WEST SUSSEX COUNTY COUNCIL CONSULTATION

TO:	Arun District Council FAO: David Easton
FROM:	Highways, WSCC
DATE:	5/07/2018
LOCATION:	Land west of Brook Lane and South of A259 Angmering
SUBJECT:	A/46/18/RES Approval of reserved matters following outline consent A/169/17/OUT for access. This application also lies within the parishes of Littlehampton & Rustington.
DATE OF SITE VISIT:	N/A
RECOMMENDATION:	☐ Advice ☐ Objection ☐ Modification ☒ No Objection ☐ More Information ☐ Refusal
S106 CONTRIBUTION TOTAL:	N/A

Application A/46/18/RES seeks approval of the reserved matters in relation to access associated with application A/169/17/OUT. The applicant is proposing a left in left out vehicular access from the A259.

title
POSSIBLE LINKAGE TO ADJACENT SITE

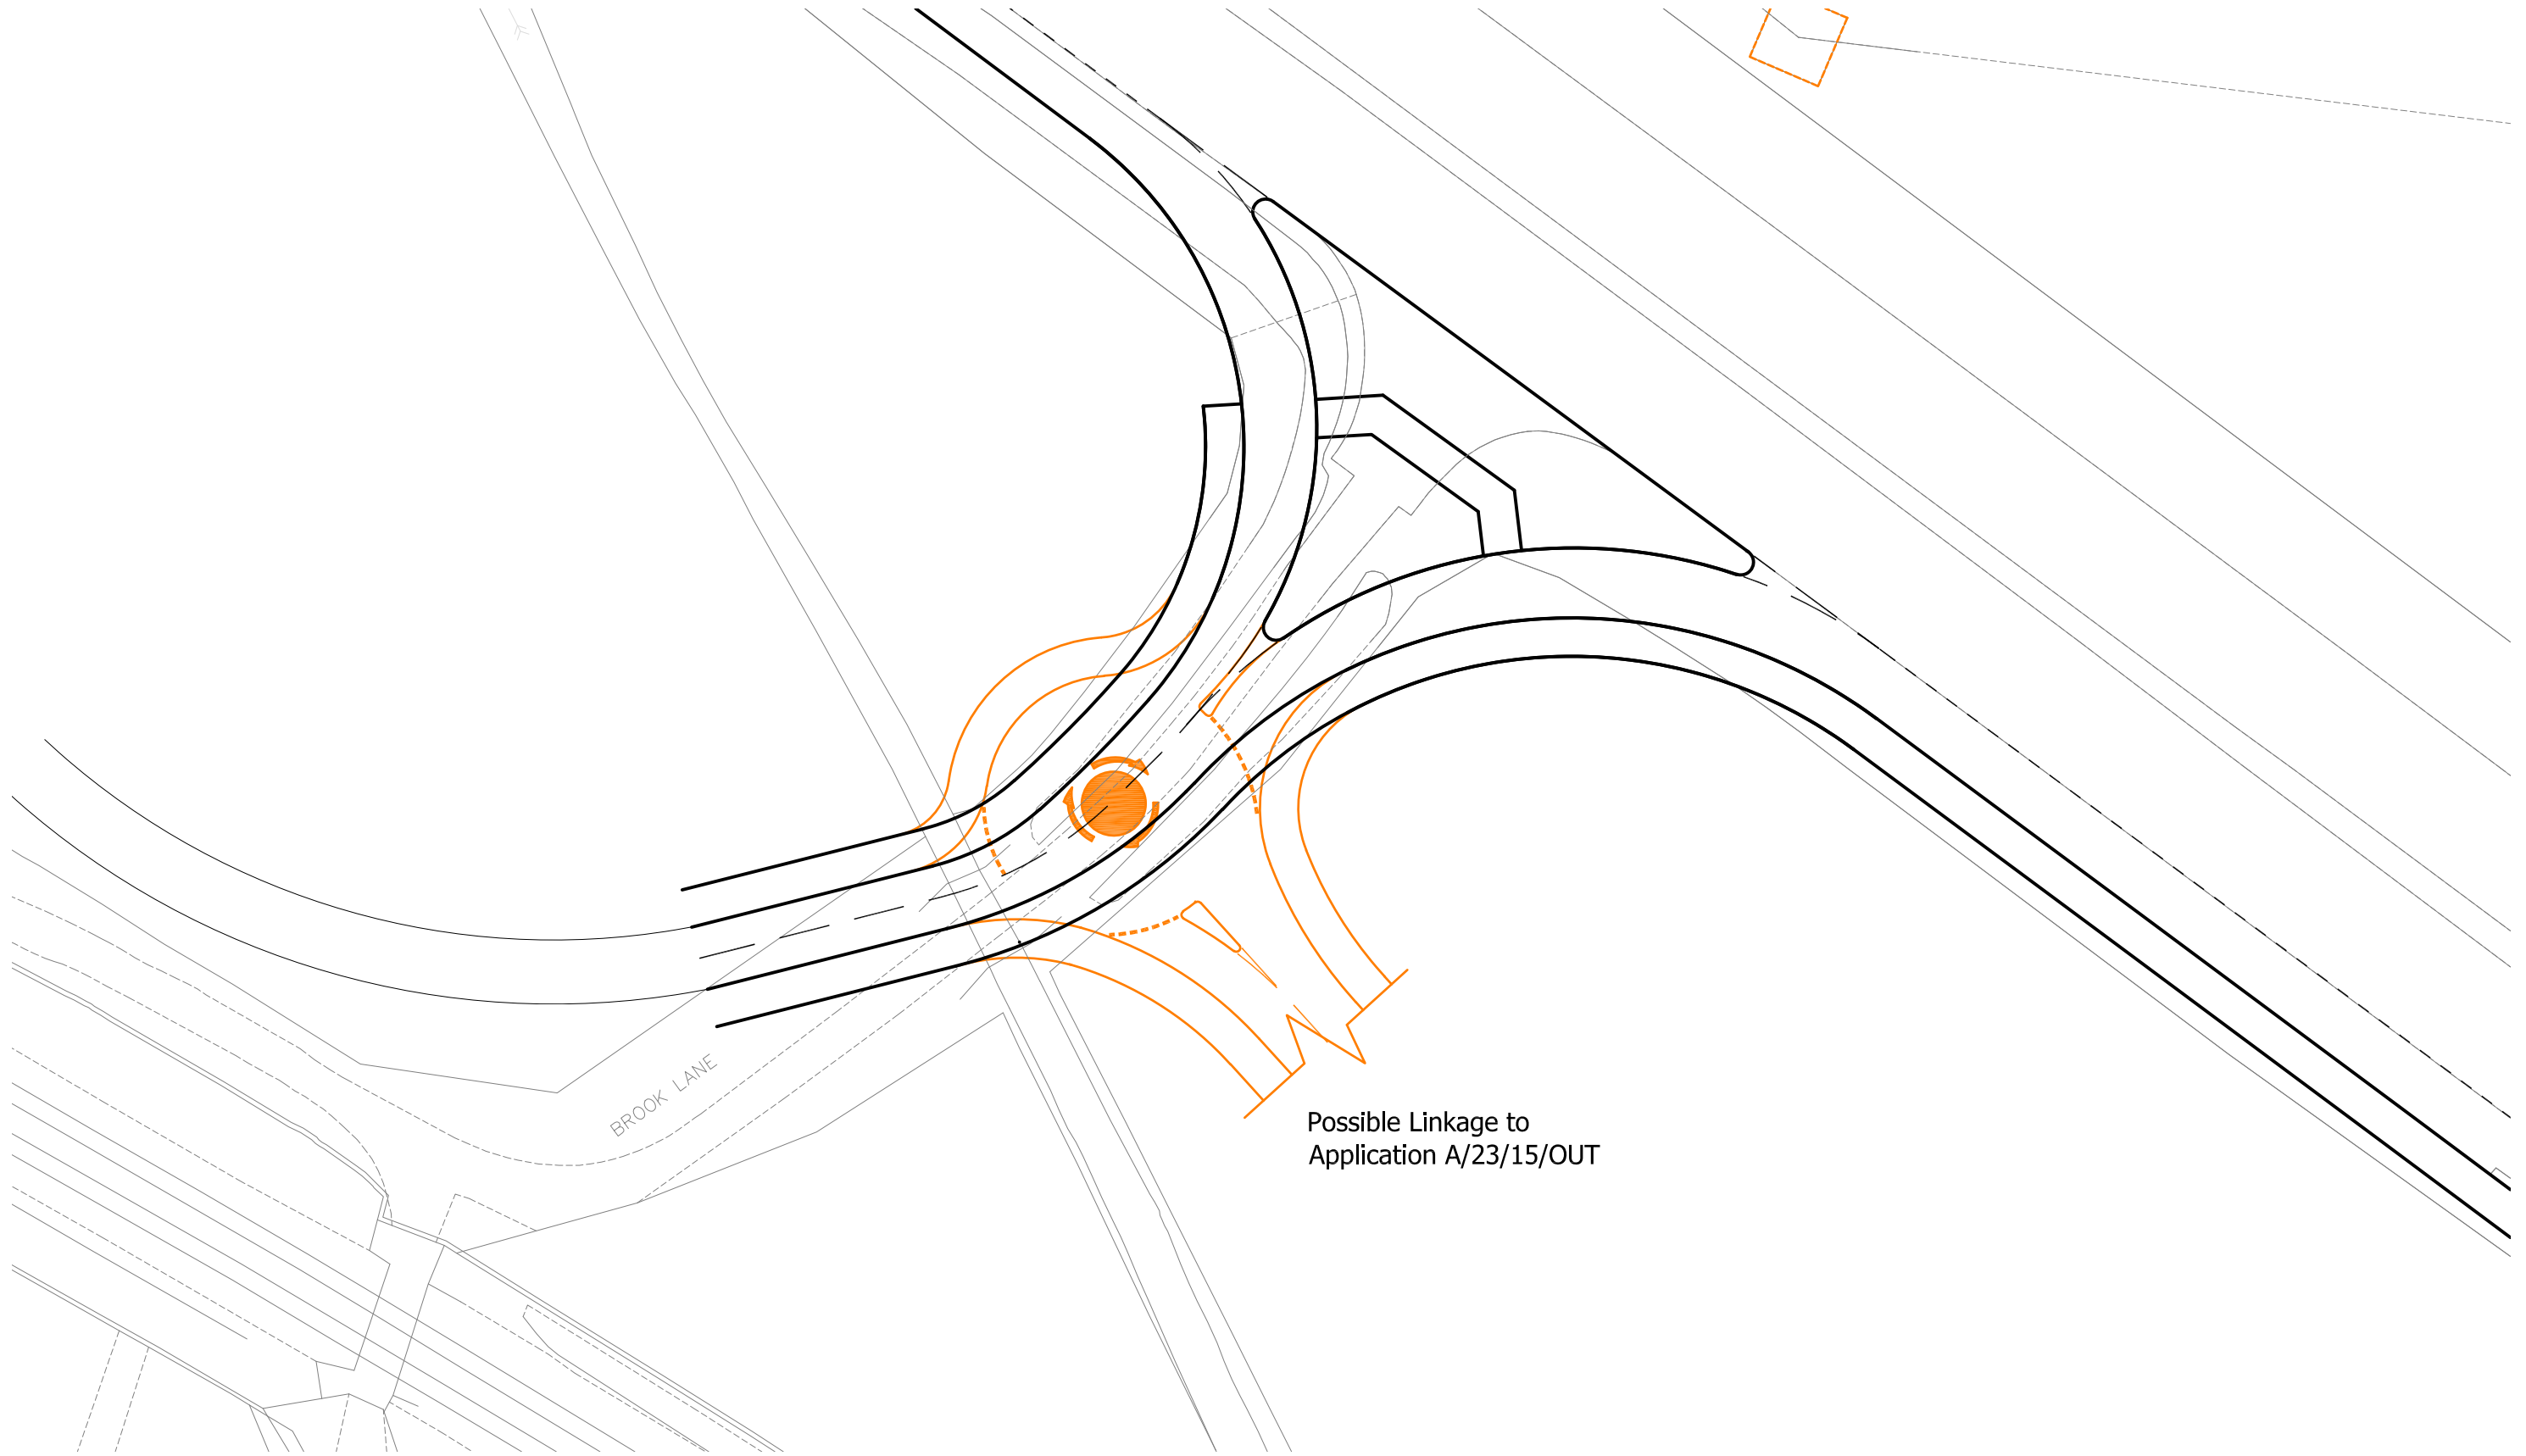
The applicant has undertaken a design review and stated that there are no departures from standard and undertaken a Stage 1 Road Safety Audit and provided a designers response. The applicant has submitted a drawing entitled Possible Linkage to adjacent site (Drawing Number SPRUST(BROOK LANE) 1/10) which demonstrates that a potential connection can be provided to the adjacent site (application A/23/15/OUT) which Arun Planning Committee were minded to approve at the May committee. This therefore demonstrates that the proposed access does not preclude the application (A/23/15/OUT), which is minded to approve, from coming forward; subject to agreement of rights of access which are private non planning matters. Given that the applicant has demonstrated that the adjacent scheme which is minded to grant (A/23/15/OUT) can still be accessed and that this application does not preclude the consented scheme from coming forward the Highway Authority would not object to this application.
